Your Ref: OWPC26179
Our Ref: BN/18/20/PL 19-02-2020
Please ask for:
Maria Tomalova

Variation of condition 15 imposed under EG/29/13/ relating to condition 15 - to change the foul drainage scheme from Sewage Treatment Plant to Pumping Station with associated drainage works.

Former Brooks Nursery Eastergate

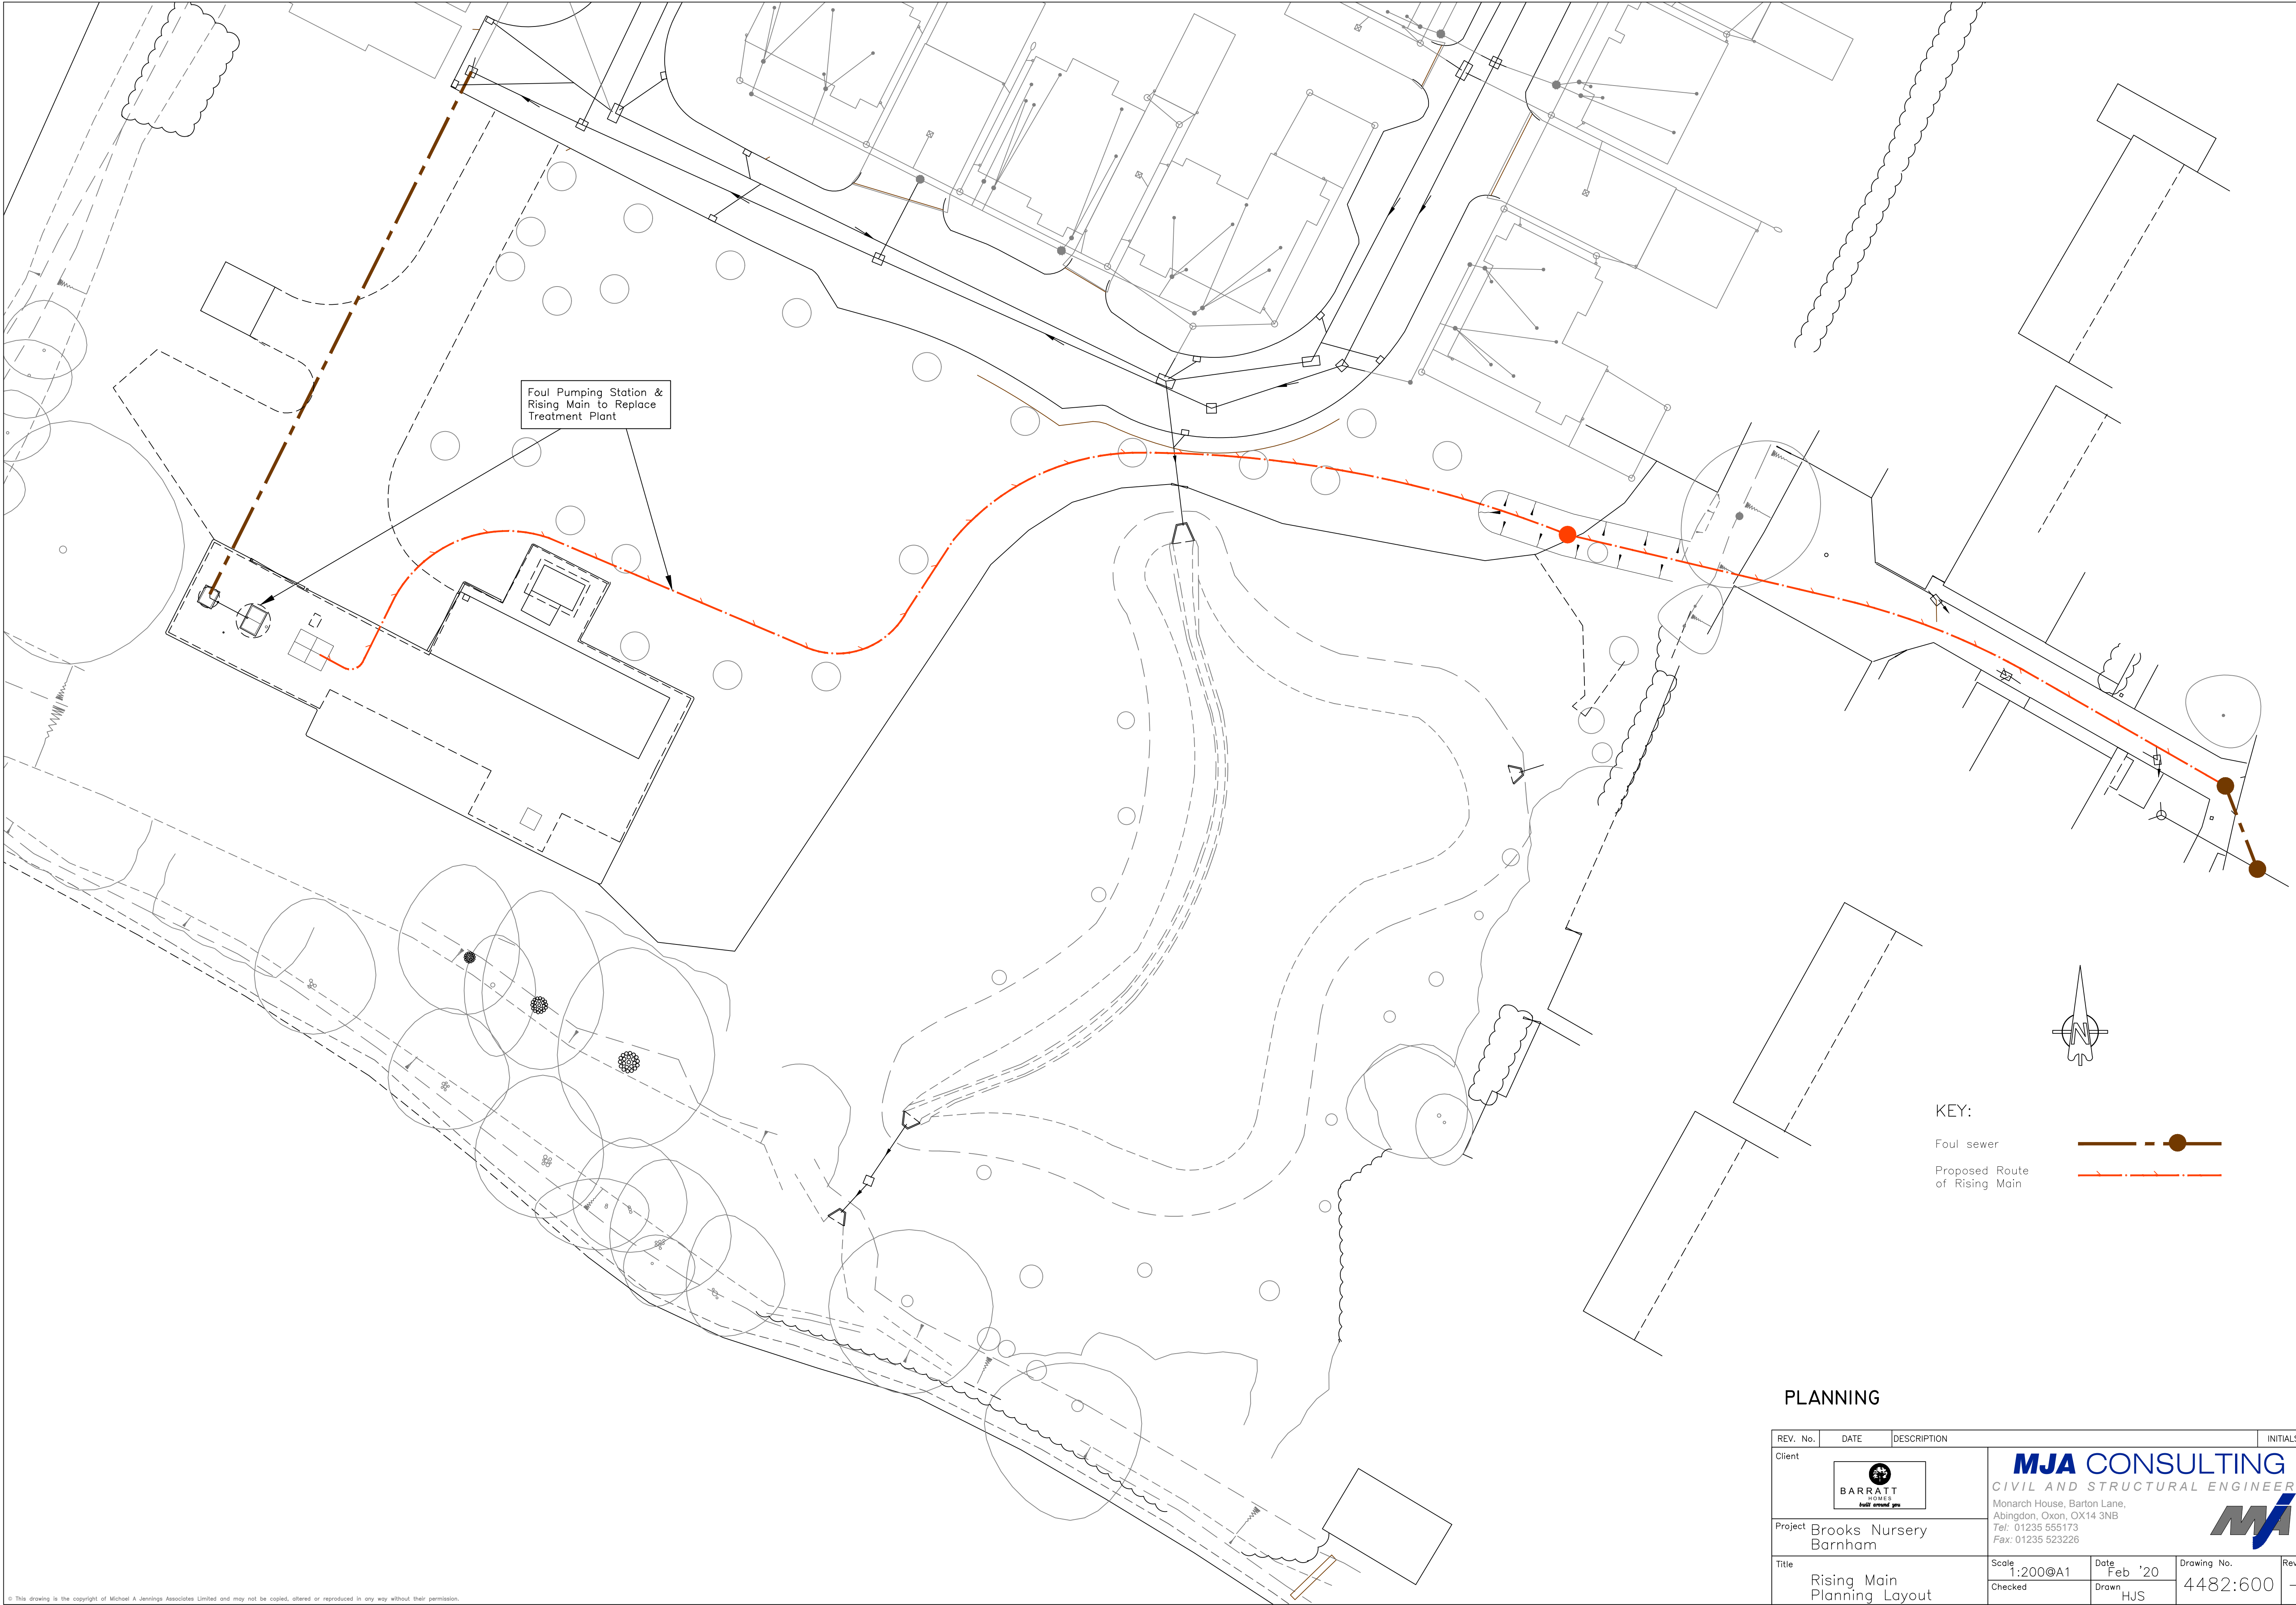
- 3. I do not believe that an already aged system of pipework will cope with extra load that will be impacted upon it. Given consideration that you intend to join an 8 inch pipe to our existing 6 inch pipe does not give confidence that problems such as blockages, spills & flooding from sewer will occur.*
